**West Cliff Colliery Diesel Storage and Refuelling Facility
Response to Submissions**

APPENDIX A

AGENCY SUBMISSIONS

GENERAL ARRANGEMENT

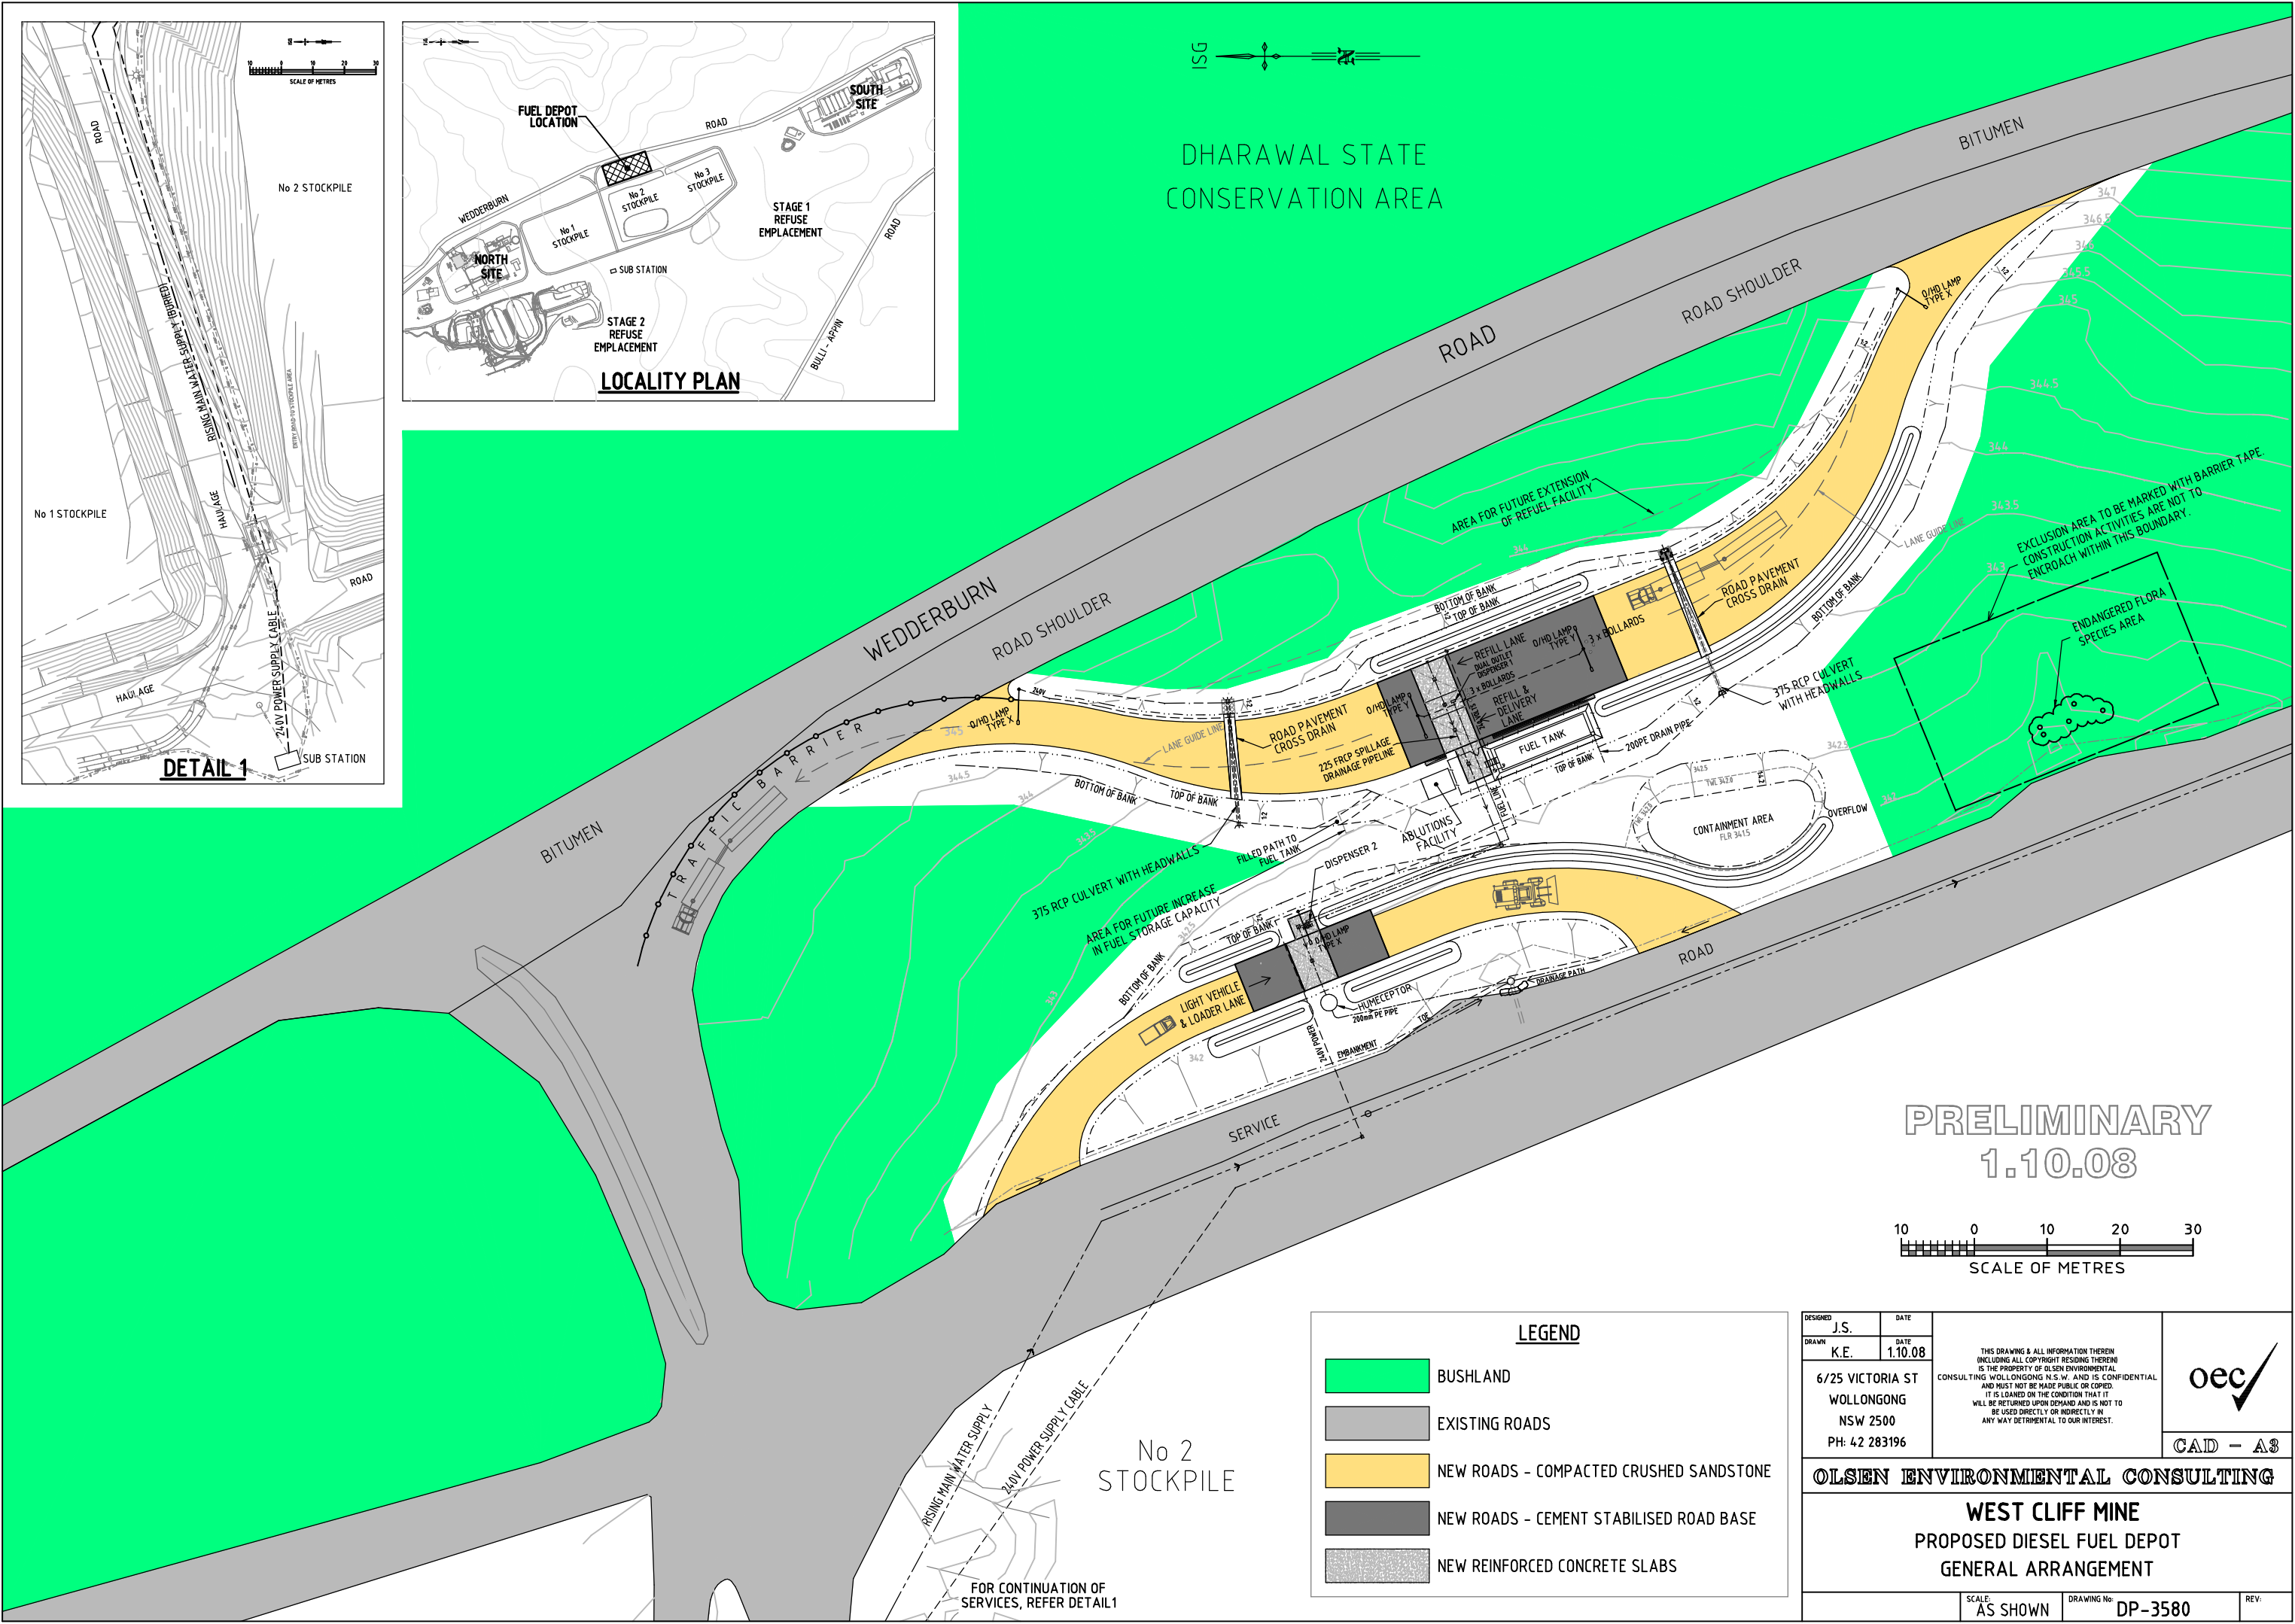
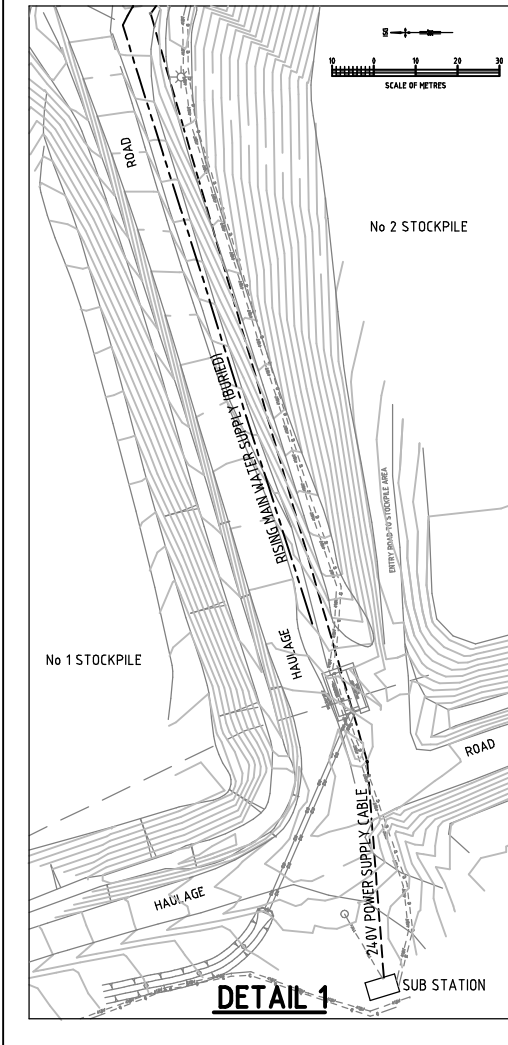
Queries were raised regarding the capacity of the primary spillage pond to effectively manage the any diesel spillage from the facility without discharge. The proposed facility will have a double skinned tank, and in addition to the addition to the primary spillage pond, a “Humeceptor” is also proposed to capture runoff and spills from the refuelling area. Modelling has been carried out on the existing water management system at West Cliff, and with the addition of hard standing area the site has sufficient capacity to capture all spills from the facility under a range of operating scenarios. In the unlikely event that any spillage should leave the facility, the existing treatment facilities contained within the Water Management System on site will be capable of treating the water up to a design storm event of 1:10 year frequency and 72 hour duration.

A query was made in regard to whether the containment overflow would affect the threatened *Pultanea Aristata* identified in the area. The area has been checked and the overflow will flow into an existing rock channel, which will not affect the plants. The plants are located on the high side of this channel, and will be unaffected by these flows.
